REQUEST

Current Zoning: N1-A (neighborhood 1-A)
Proposed Zoning: UR-2(CD) (urban residential, conditional)

Approximately 4.2 acres located on the north side of Galloway Road, east of Mallard Creek Road, and west of Garrison Road.

The petition proposes a residential community of up to 28 single-family attached dwelling units.

REZONING SITE PLAN

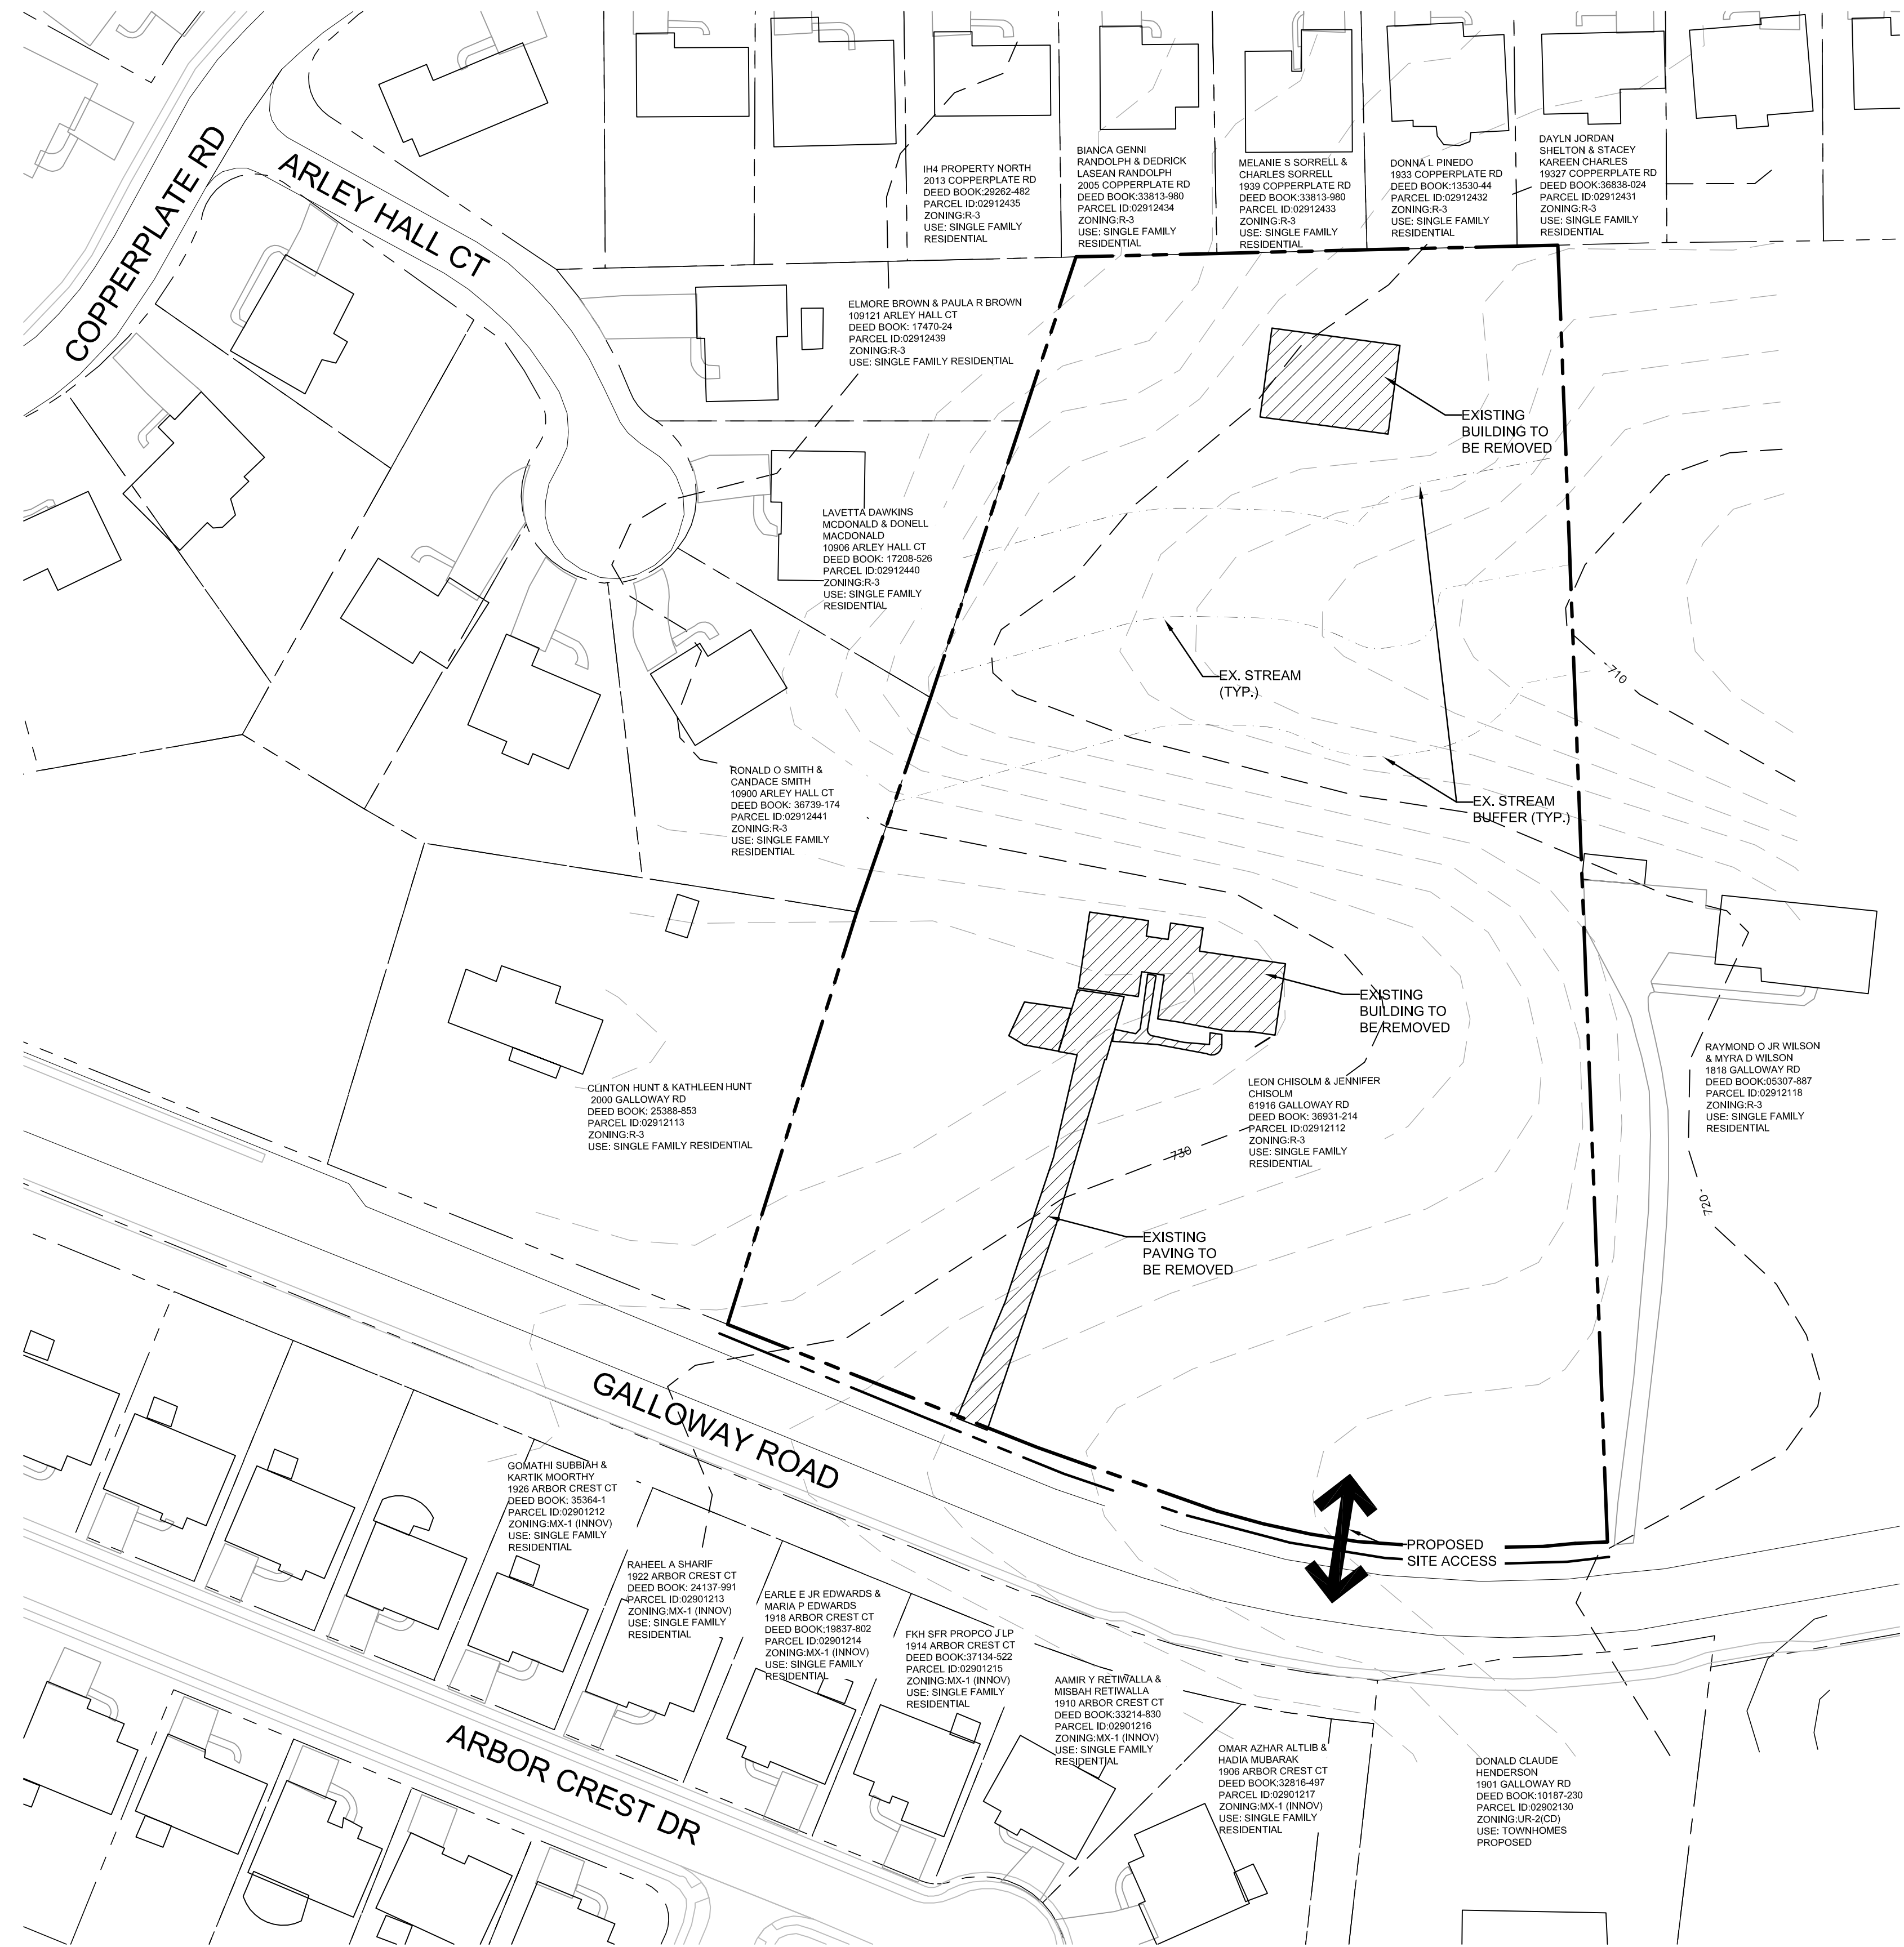
1. Remove "visible from", changing to "proposed along" to read: "Garage doors proposed along public..." for architectural note 8. **Addressed**
2. The setback in the site data table says 35' from BOC. please show correct setback. **Addressed**
3. The rear yard in site data table say 10'. Please add or 20' as shown. **Addressed**
4. Change the height in site data table to say 40', with allowance up to 48' per 9.406(2)(a) **Addressed**
5. Change architectural note 5 from 4 units to 3 units fronting Galloway Road. **Addressed**
